CITY OF MERCER ISLAND

July 18, 2016

RE: Request for Information - File Nos. SEP16-015/ZTR16-002
Mercer Island Center for the Arts
3205 77th Avenue SE
Mercer Island, WA 98040;
King County Tax Parcel # 1224049068

MERCER ISLAND CENTER FOR THE ARTS CONCEPTUAL MITIGATION PLAN

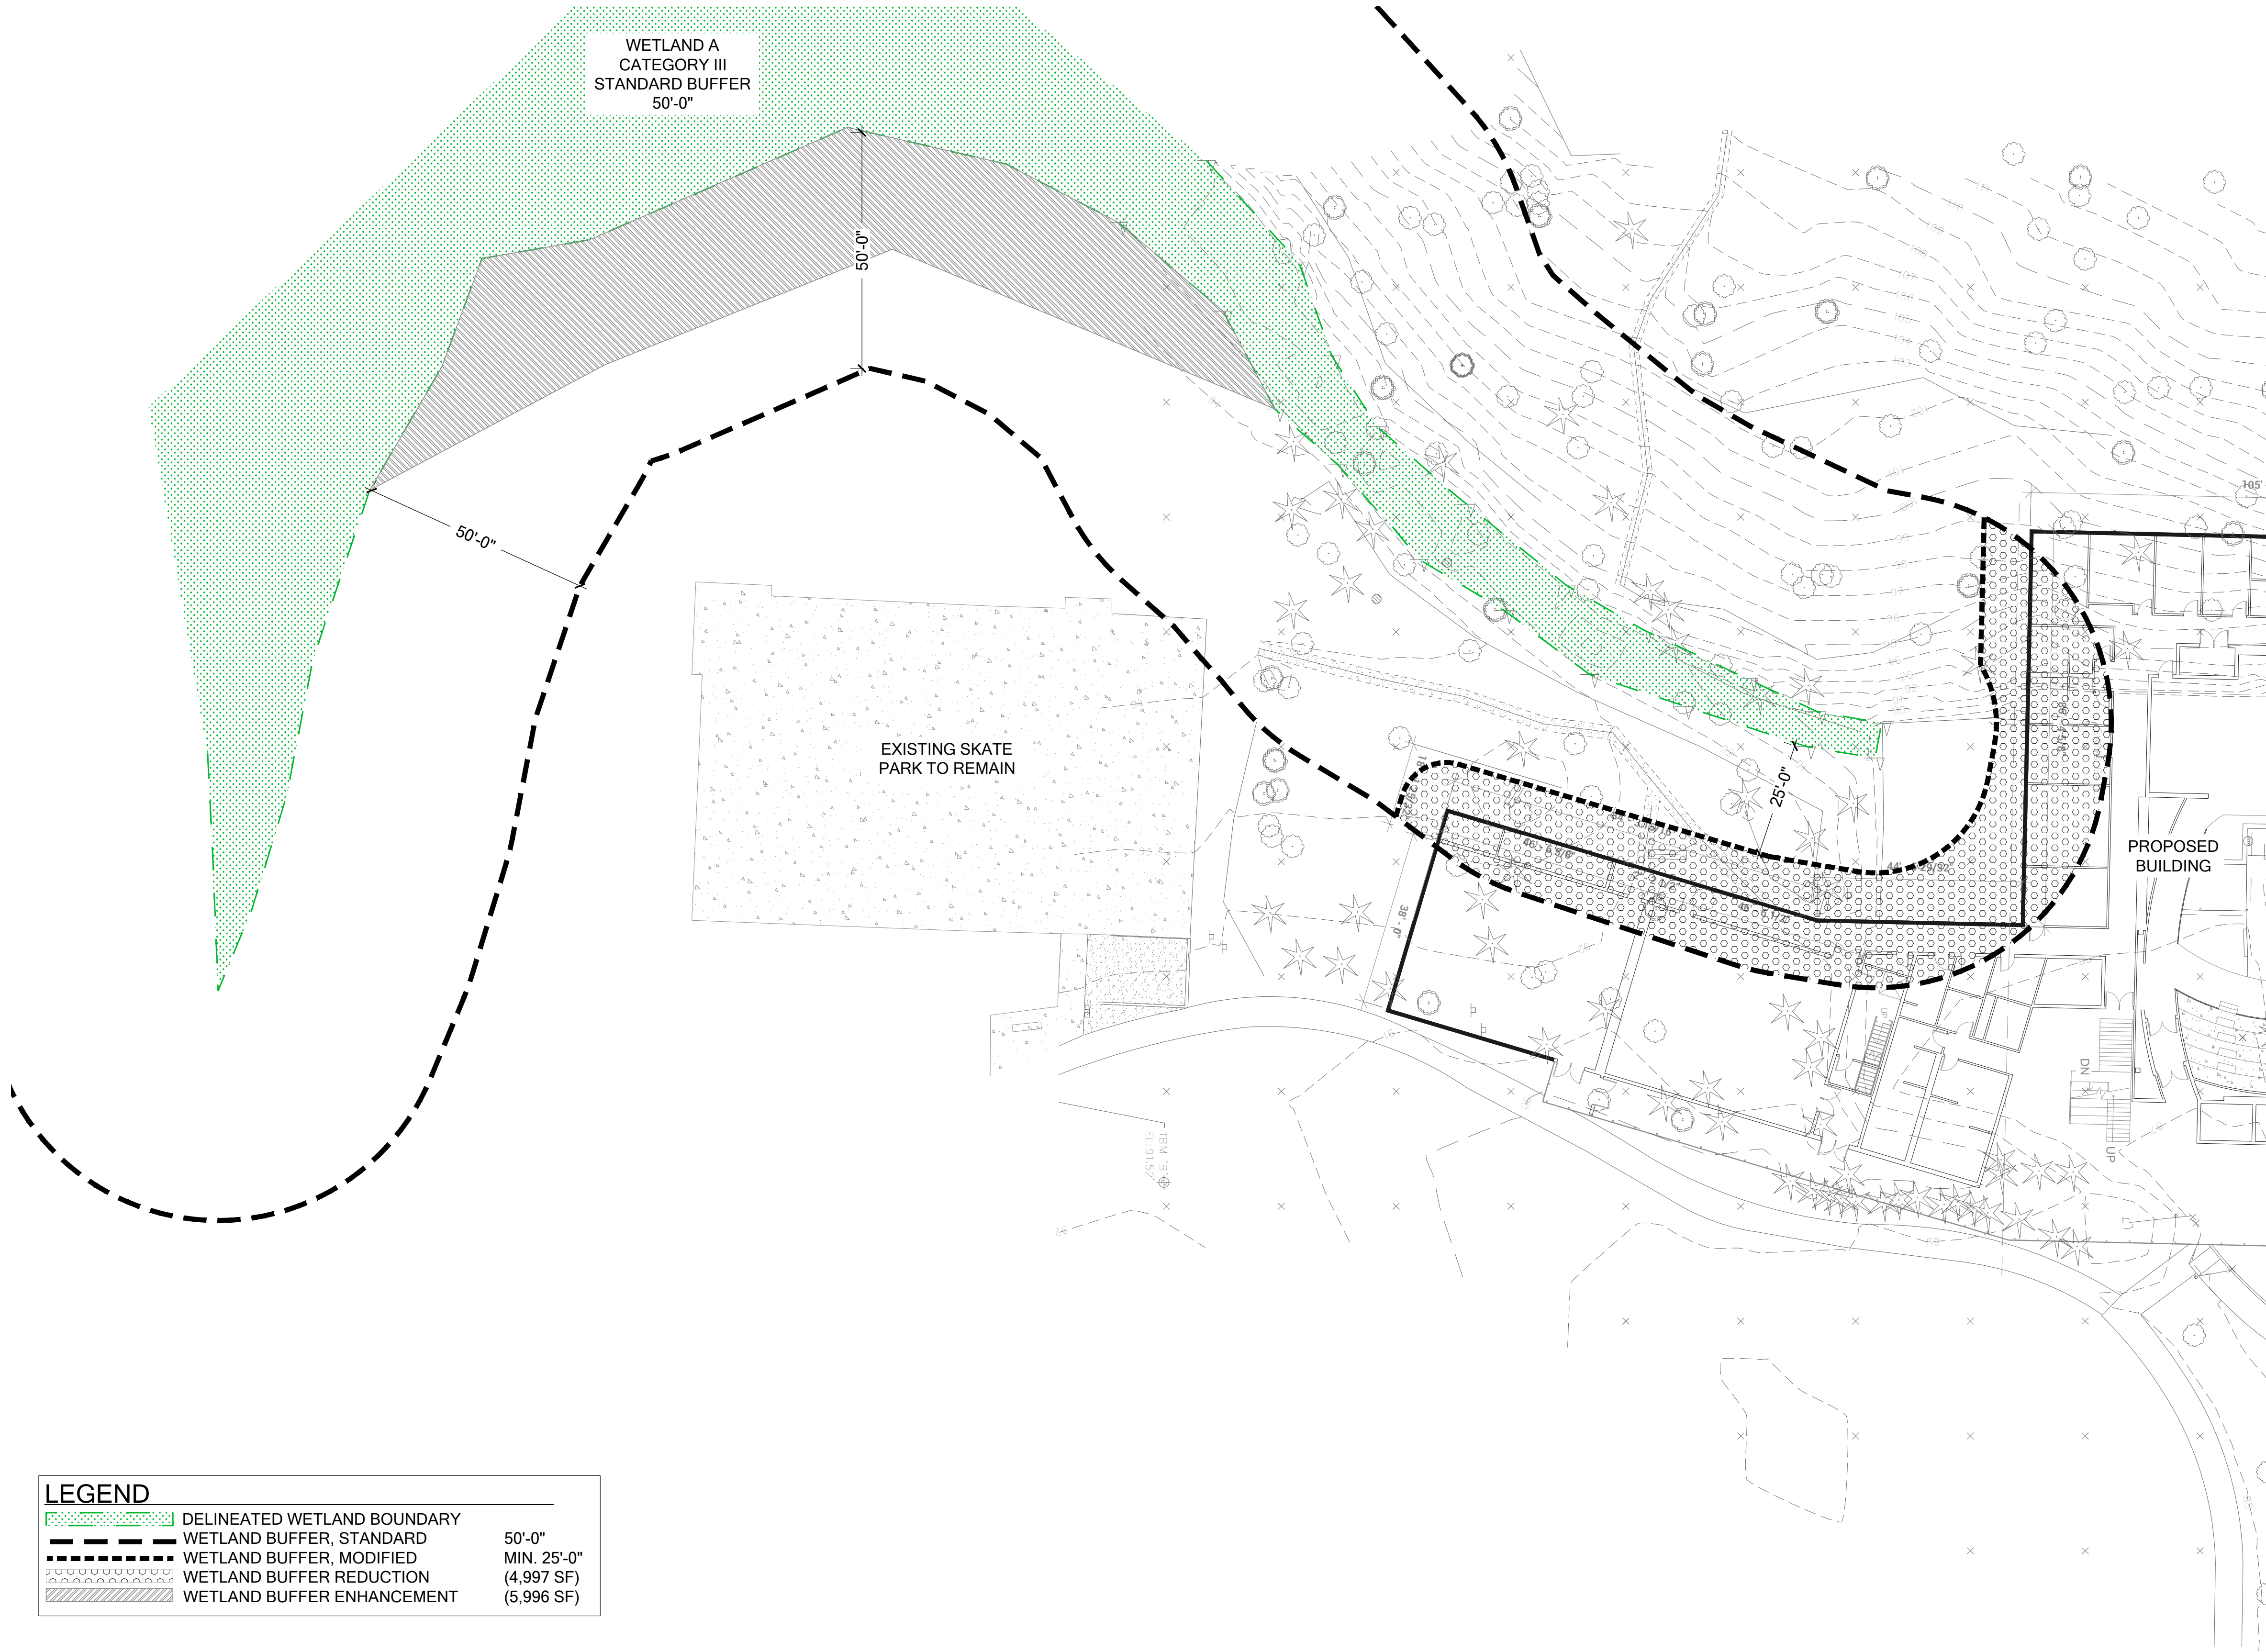
5. Attachments C and D (geotechnical information) need to be updated or supplemented to reflect the currently proposed plans.
6. Attachment F (wetland mitigation proposal) needs to be updated or supplemented to reflect the currently proposed plans and proposed mitigation.

1 SHORT PLAT
1" = 50'-0"

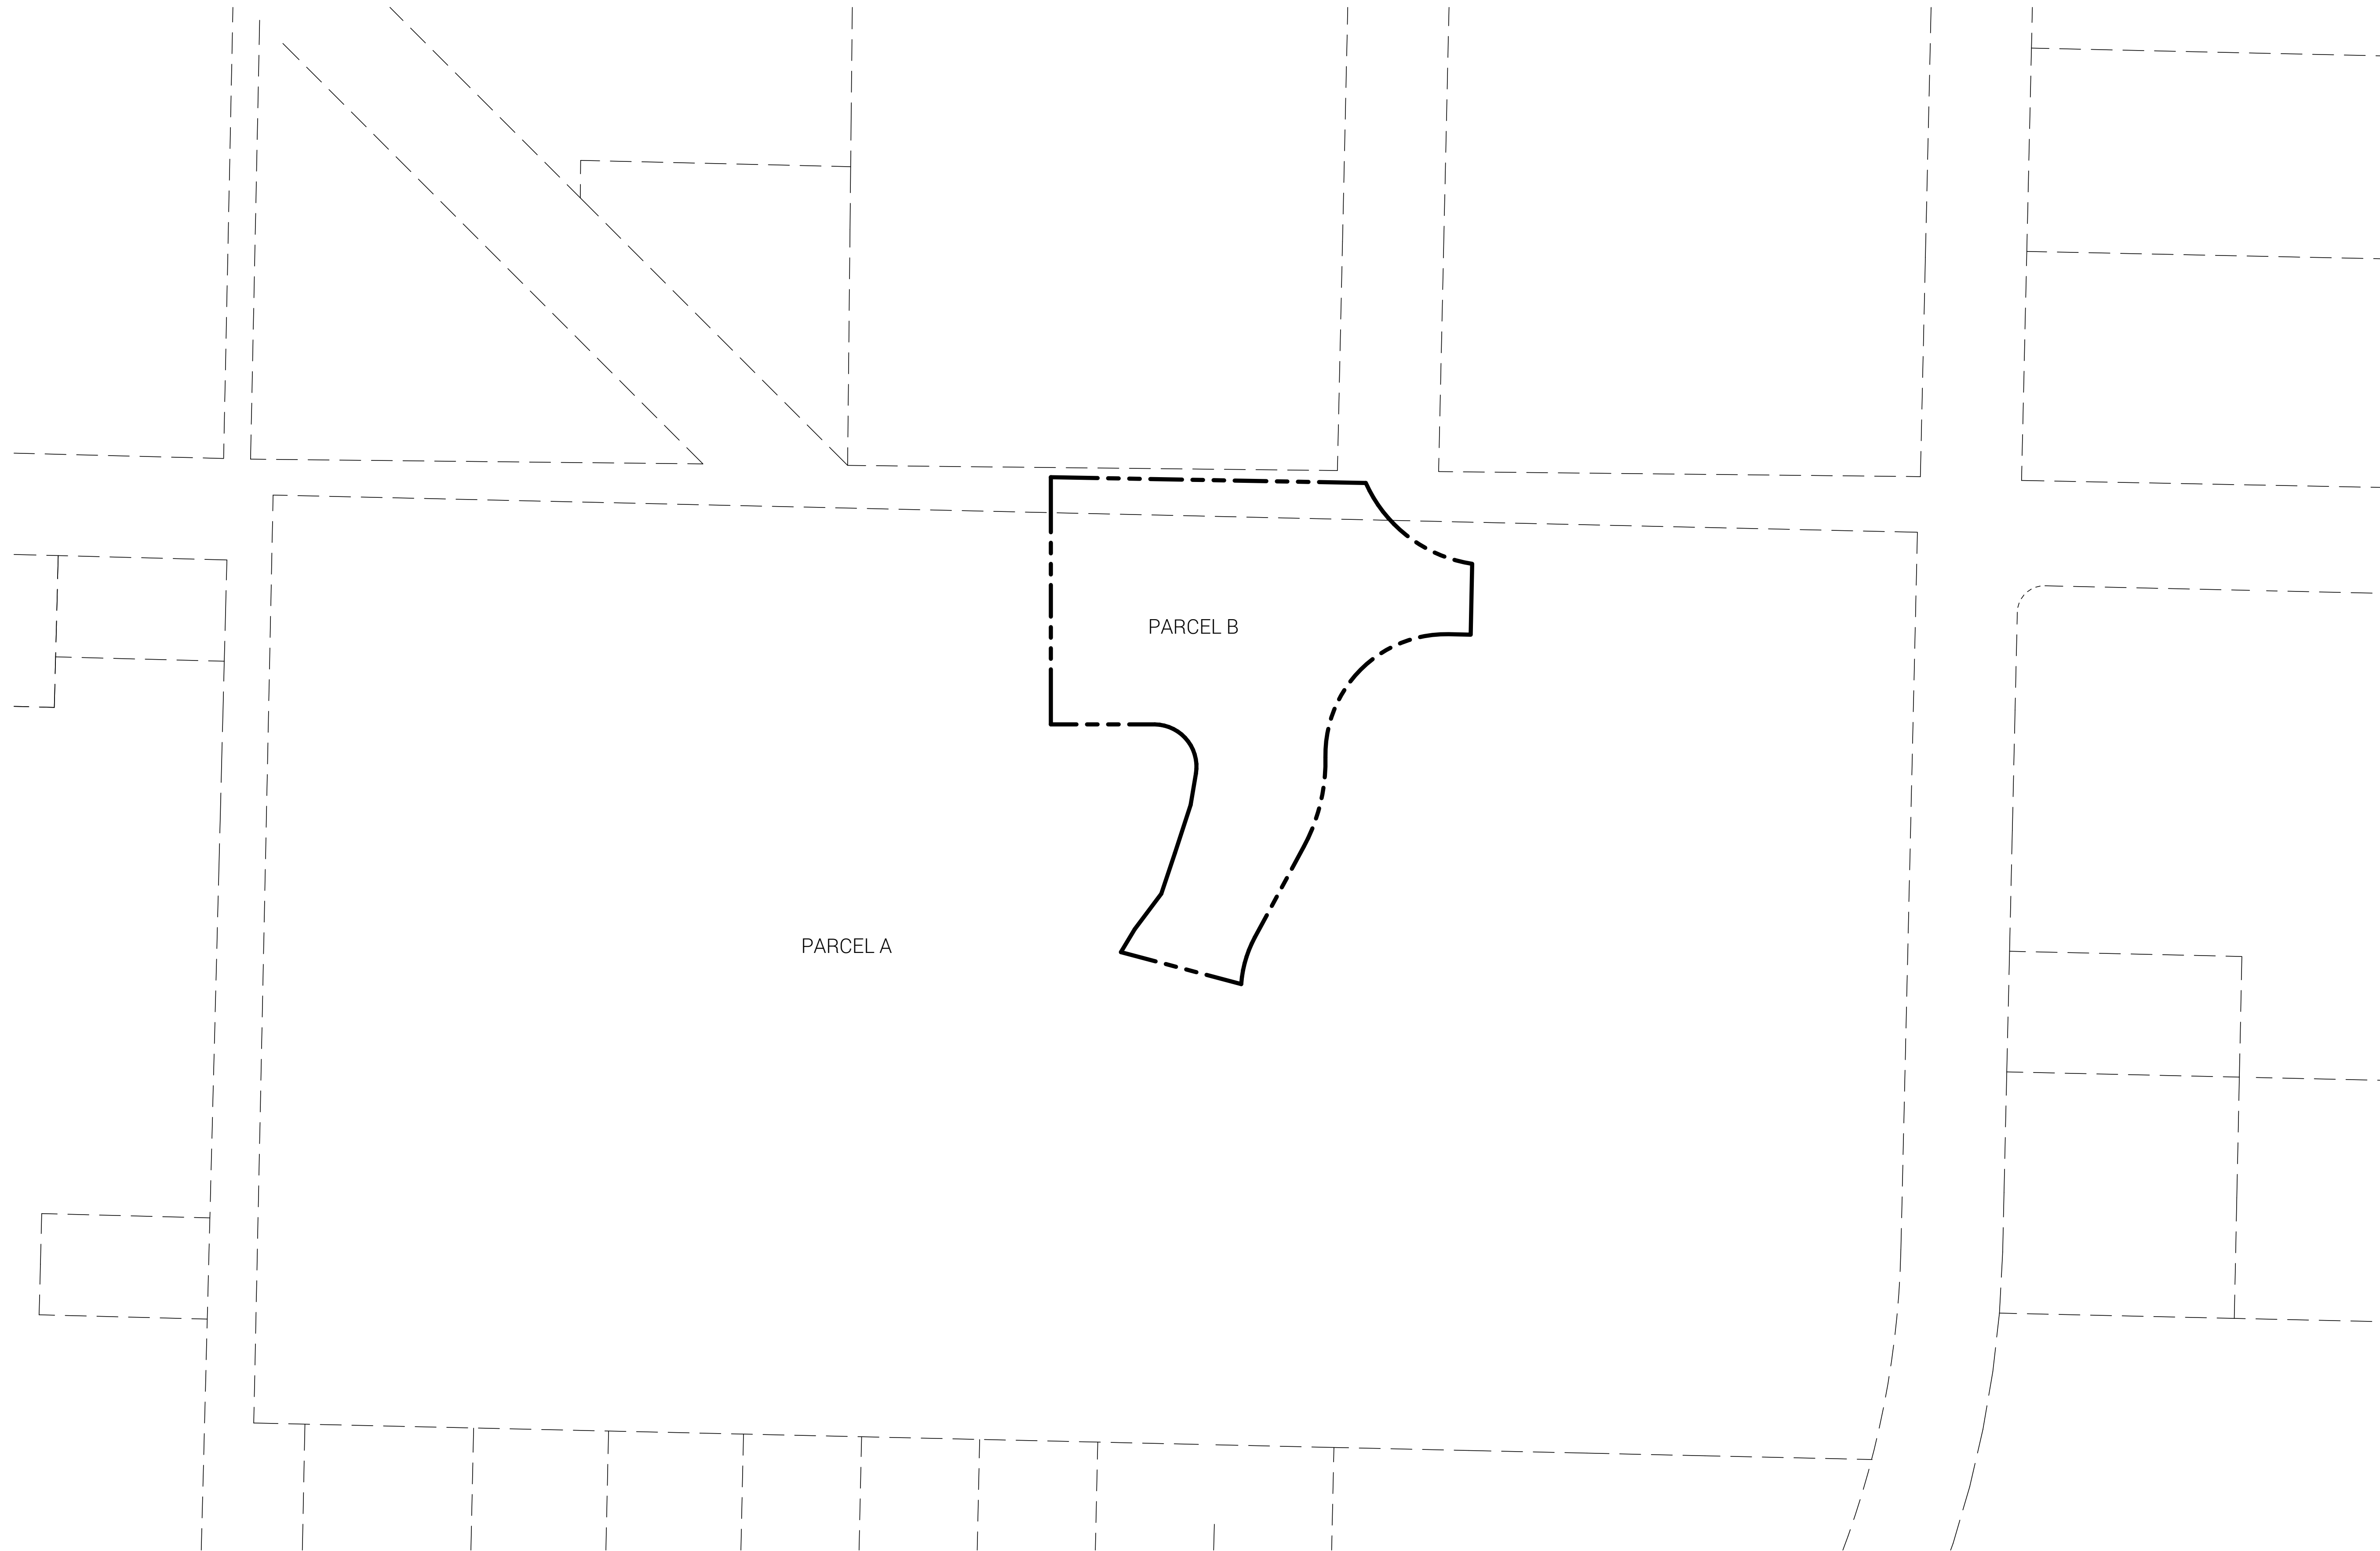
1. MICC 19.16.010 defines "subdivision" as: *"The division or platting of, or the act of division or platting of, land into two or more lots for the purpose of transfer of ownership, building development, or lease, whether immediate or future, and shall include all resubdivision of land."* (emphasis added) Please modify the submitted SEPA Checklist to include a short subdivision (short plat) as part of the project.
2. MICC 19.09.090 requires designation of a building pad for each lot in a short plat. The designated building pads need to be shown as part of the supporting materials for the SEPA Checklist to allow evaluation of any environmental impacts. Please submit supporting information showing how the proposed building pads comply with MICC 19.09.090:
